DECISION DELEGATED TO DEVELOPMENT MANAGER

Application No: H02-0201-21 **Applicant:** Mr J Finding
Proposal: Proposed New Bungalow
Location: Land Adj. 10 Harrington Drive Crowland Peterborough
Terminal Date: 22nd April 2021

Project Name:	Project No:
HARRINGTON DRIVE, CROWLAND	761
Dwg No:	004
Rev:	A
Drawing Name:	Scale:
PROPOSED FLOOR PLAN	1 : 100 @A3
Drawn By:	Date:
NA	01.02.2021
Checked By:	Date:
TJM	01.02.2021

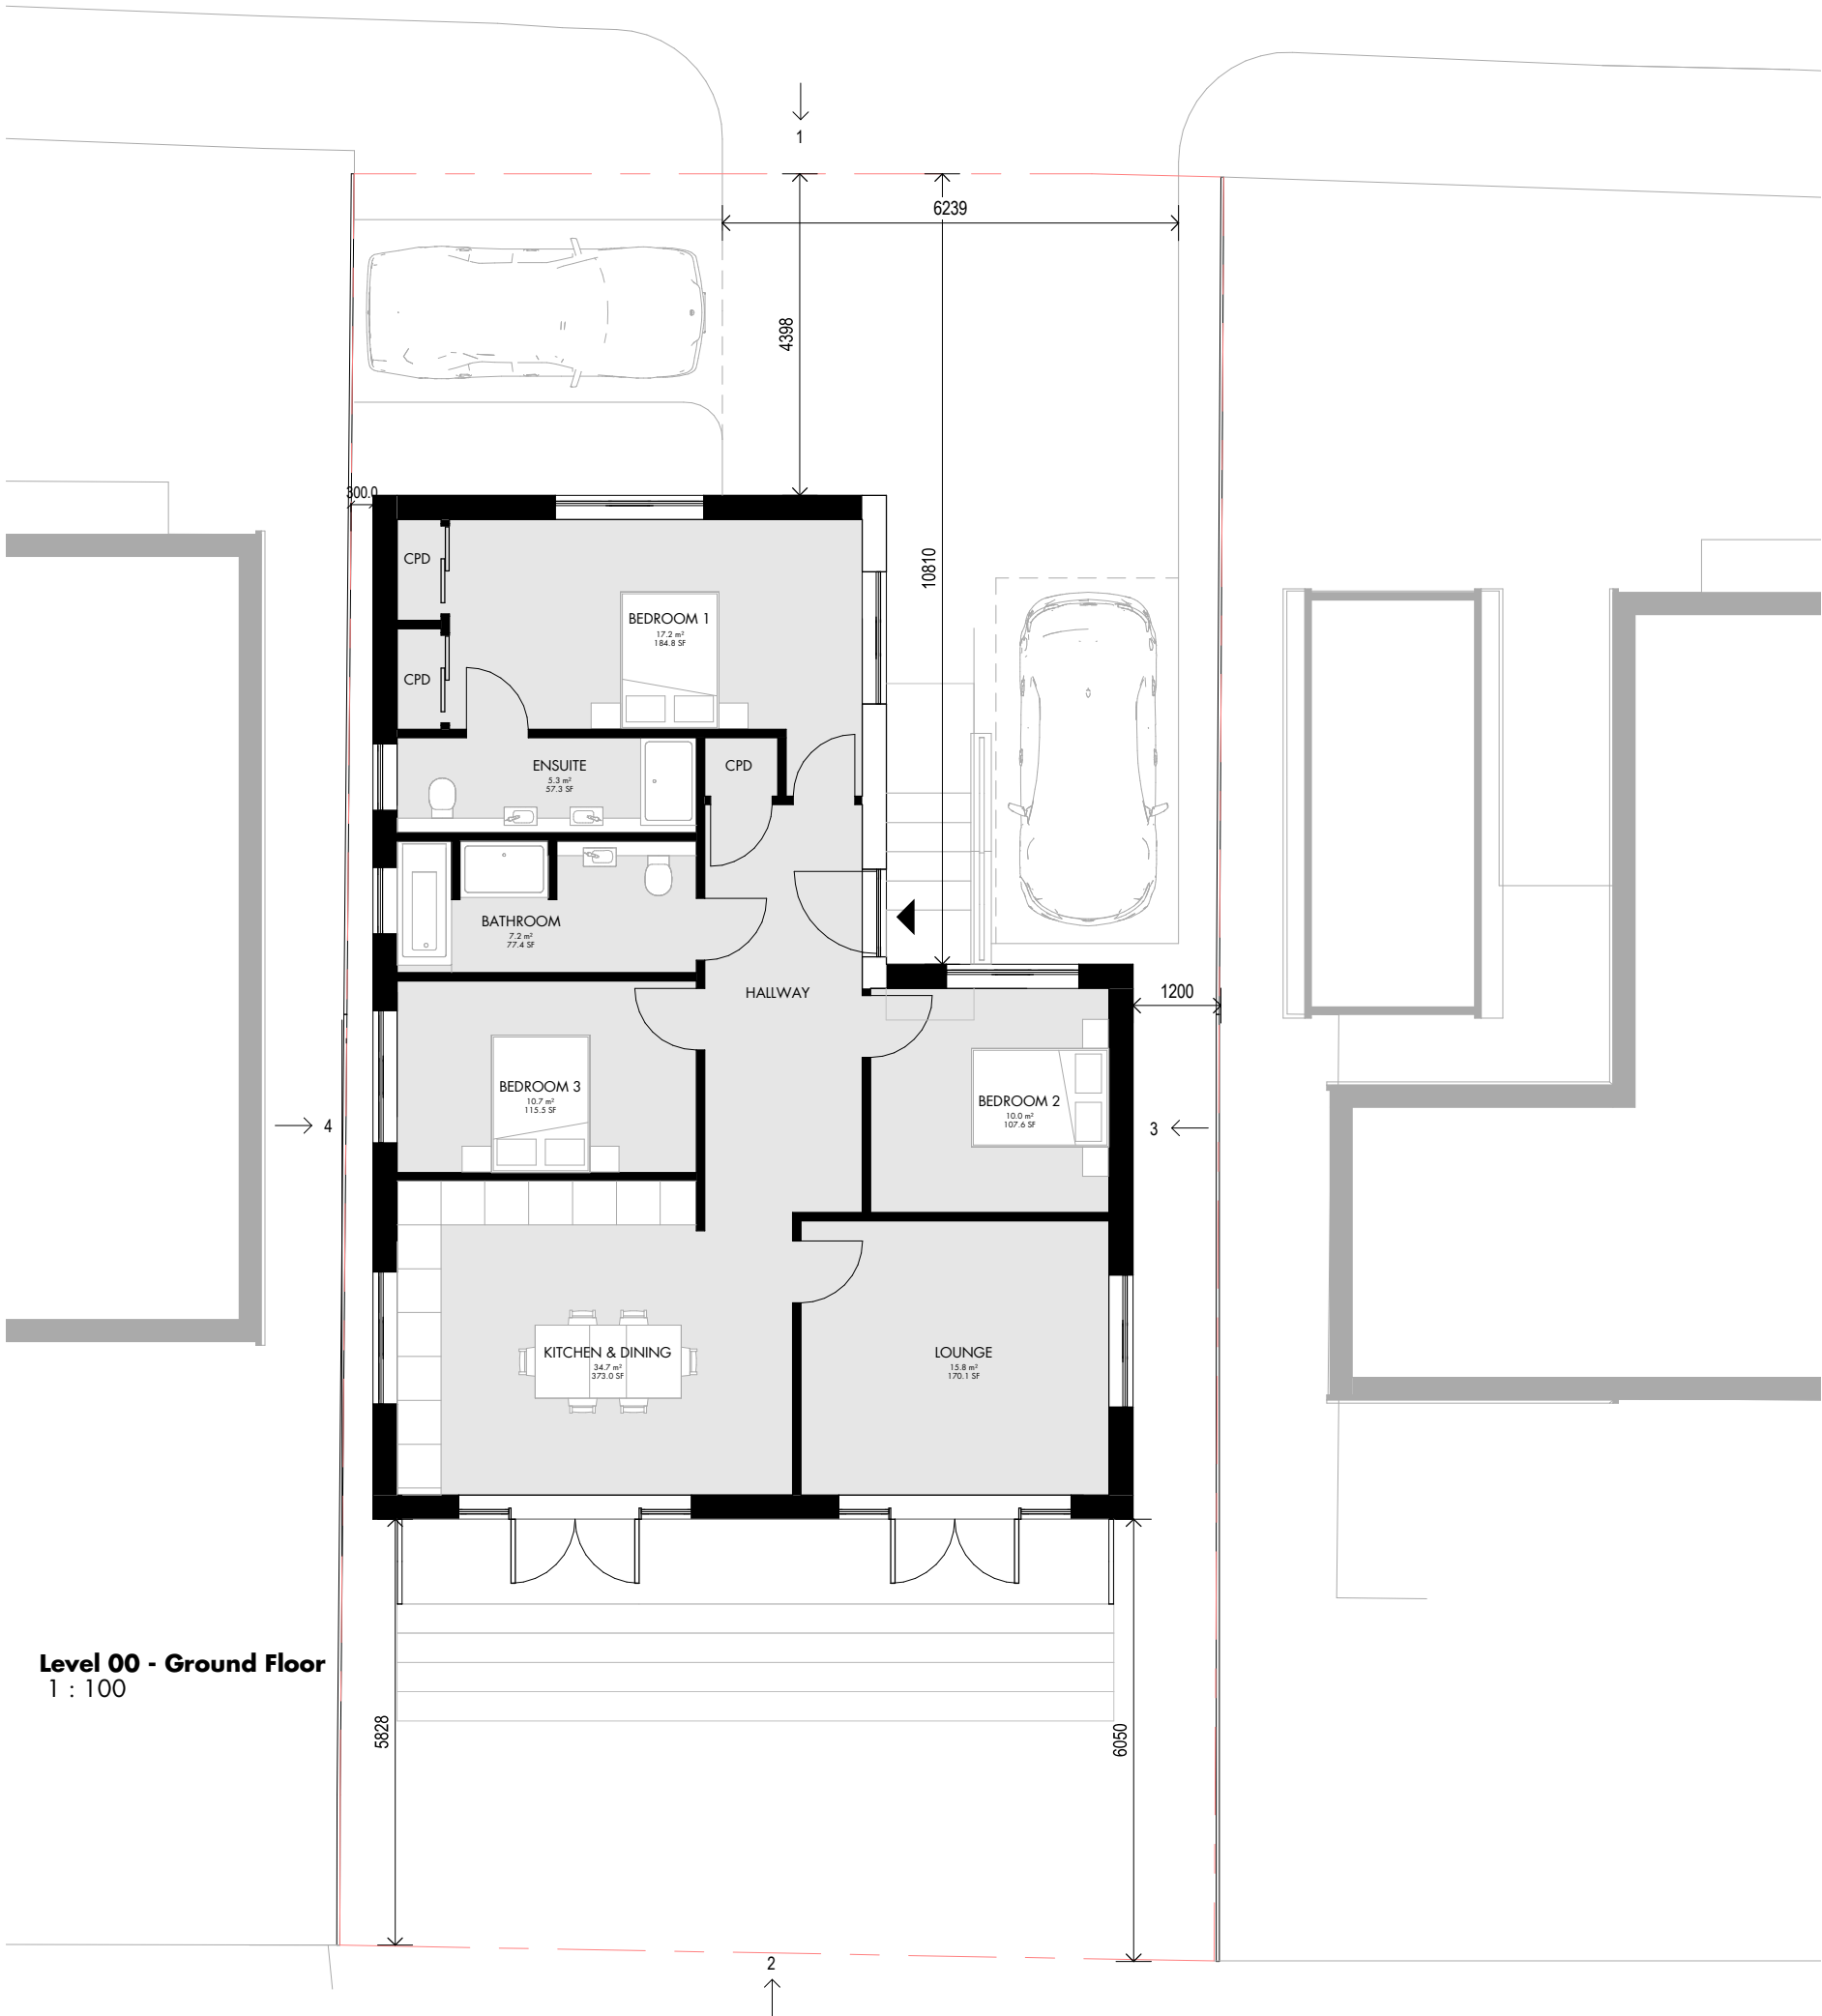
6. There is not considered to be a material impact on neighbouring land uses from noise, odour or disturbance. With regard to visual intrusion, the east facing window serving bedroom 1 and the hallway door access face the blank side elevation wall of the detached garage serving 14 Harrington Drive. The east facing window serving the lounge directly faces the blank side elevation wall of 14 Harrington Drive, however some of the upper roof of the rear elevation conservatory can be seen by the occupant. This is not considered to amount to a material overlooking aspect. The proposed decking area to the rear of the dwelling has been replaced by a stepped access to prevent material overlooking from the rear of the bungalow.

With regard to the western elevation the northernmost two side elevation windows serve an en-suite and a bathroom and will be obscure glazed. The two southernmost side elevation windows serve bedroom 3 and a kitchen counter space.

11. There is not considered to be a material impact on neighbouring land uses from noise, odour or disturbance. With regard to visual intrusion, the east facing window serving bedroom 1 and the hallway door access face the blank side elevation wall of the detached garage serving 14 Harrington Drive. The east facing window serving the lounge directly faces the blank side elevation wall of 14 Harrington Drive, however some of the upper roof of the rear elevation conservatory can be seen by the occupant. This is not considered to amount to a material overlooking aspect. The proposed decking area to the rear of the dwelling has been replaced by a stepped access to prevent material overlooking from the rear of the bungalow.

With regard to the western elevation the northernmost two side elevation windows serve an en-suite and a bathroom and will be obscure glazed. The two southernmost side elevation windows serve bedroom 3 and a kitchen counter space.

01.02.21 FIRST ISSUE		NA	TJM
Rev	Date	Details	Drawn
Issued for:			
Project Name:		Project No:	
HARRINGTON DRIVE, CROWLAND		761	
		Dwg No:	
		007	
		Rev:	
Drawing Name:		Scale:	
PROPOSED ELEVATIONS - SHEET 2		1 : 100 @A3	
Drawn By:		Date:	
NA		01.02.2021	
Checked By:		Date:	
TJM		01.02.2021

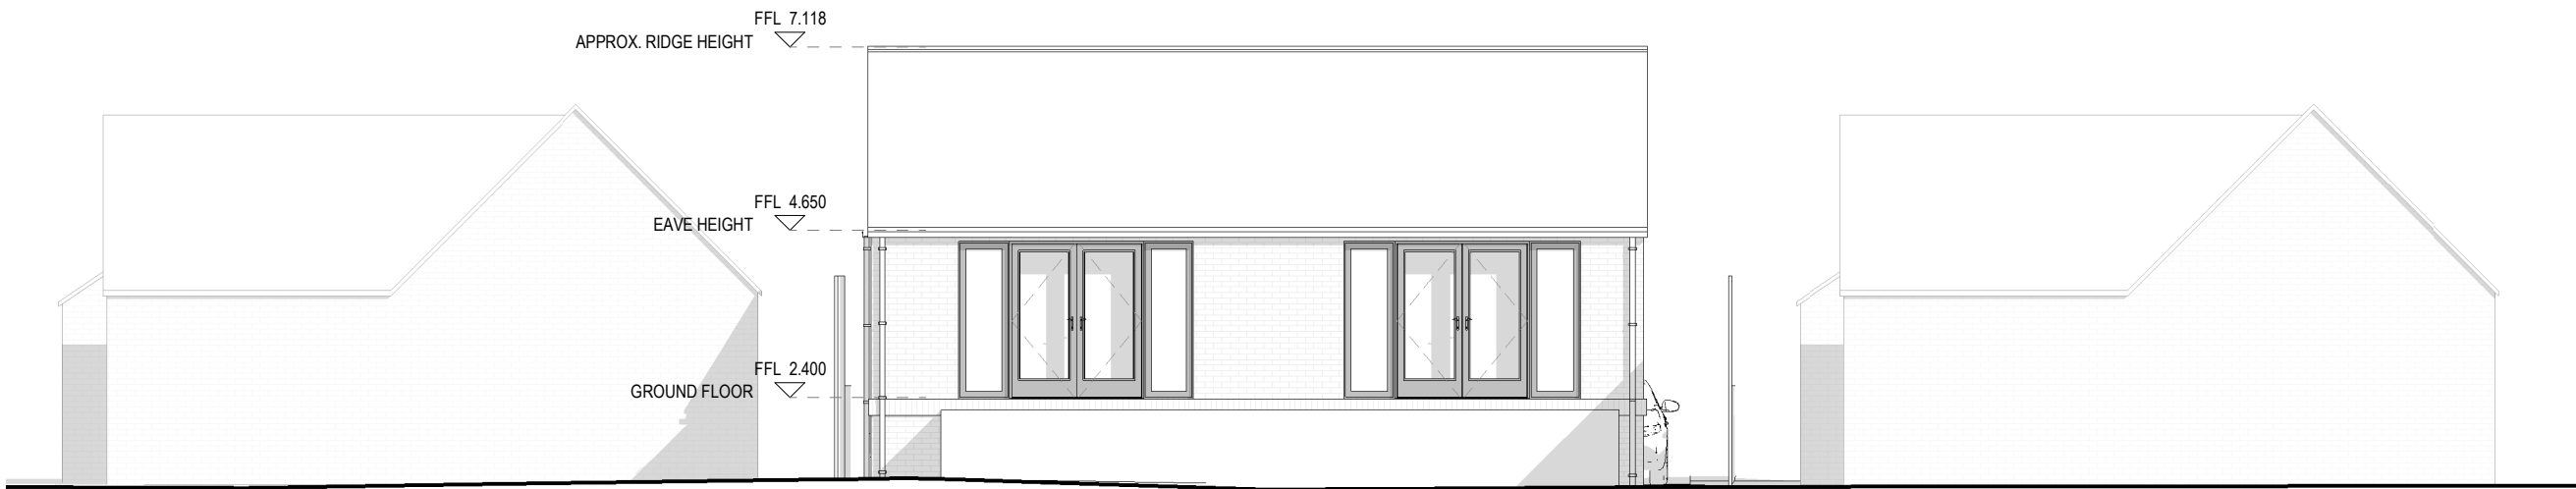
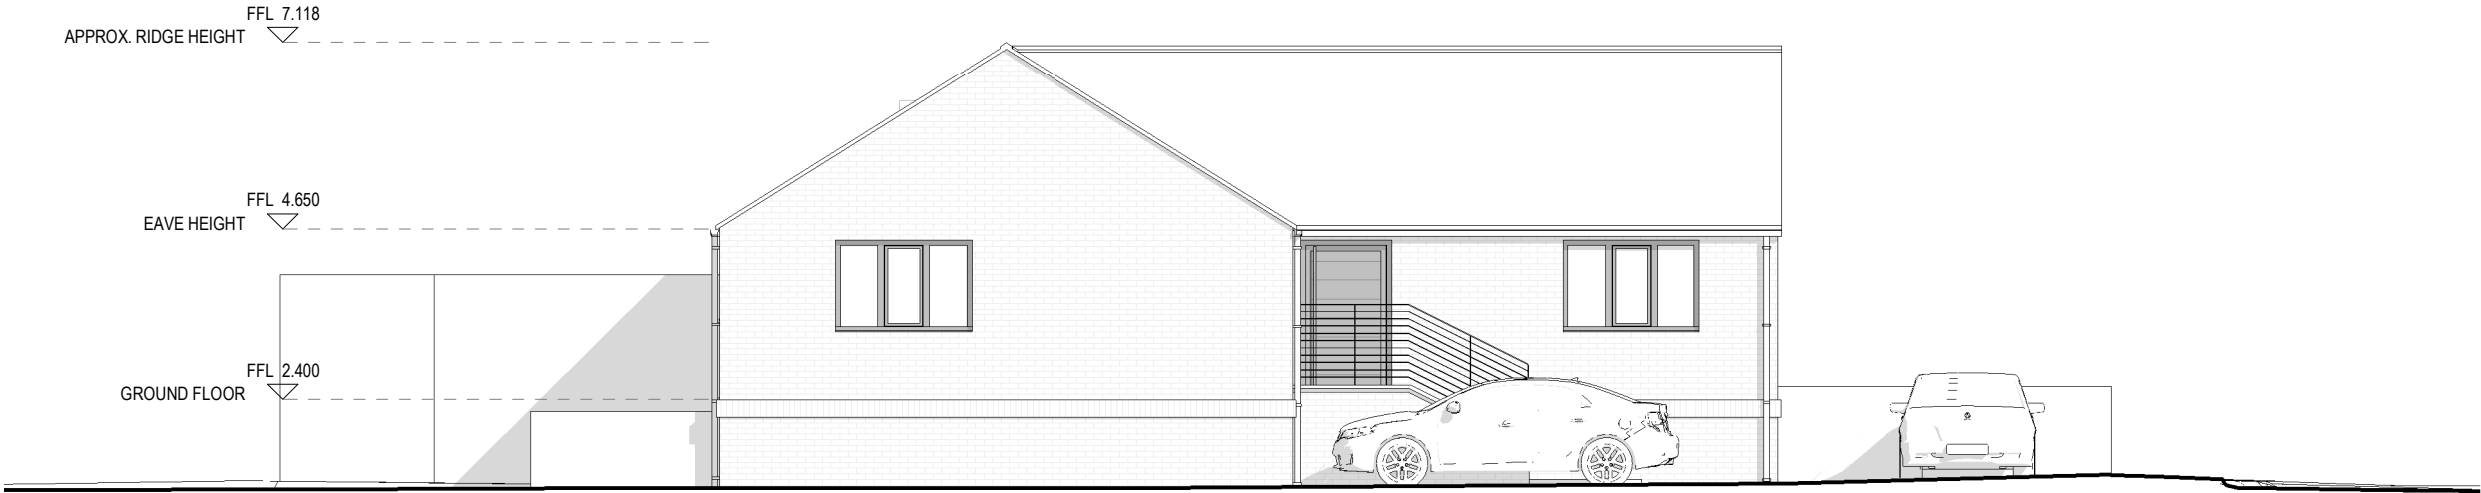
This is a full application for a proposed new bungalow on land adjacent 10 Harrington Drive, Crowland. The proposal seeks to provide three bedrooms, an en-suite, a bathroom, lounge and combined kitchen / dining area. Finished floor levels are set at 2.4mAOD, with the eaves height at 4.65 metres and a ridge height at 7.118 metres. A stepped access will be added to the rear elevation to facilitate safe egress. The side boundary fencing will be 2.2 metres in height.

1. The size and scale of the proposed bungalow is considered to be appropriate for the site. The layout is typical for a bungalow property. To address flood risk, the bungalow is raised 1.15 metres out of the ground. Whilst this does raise the bungalow higher than other bungalows in the streetscene, the location and prominence does not give material planning concerns about the impact on the character and appearance of the area.

1. With regard to a sense of place, this is not considered to be materially impacted. To address flood risk, the bungalow is raised 1.15 metre out of the ground. Whilst this does raise the bungalow higher than other bungalows in the streetscene, the location and prominence does not give material planning concerns about the impact on the character and appearance of the area.
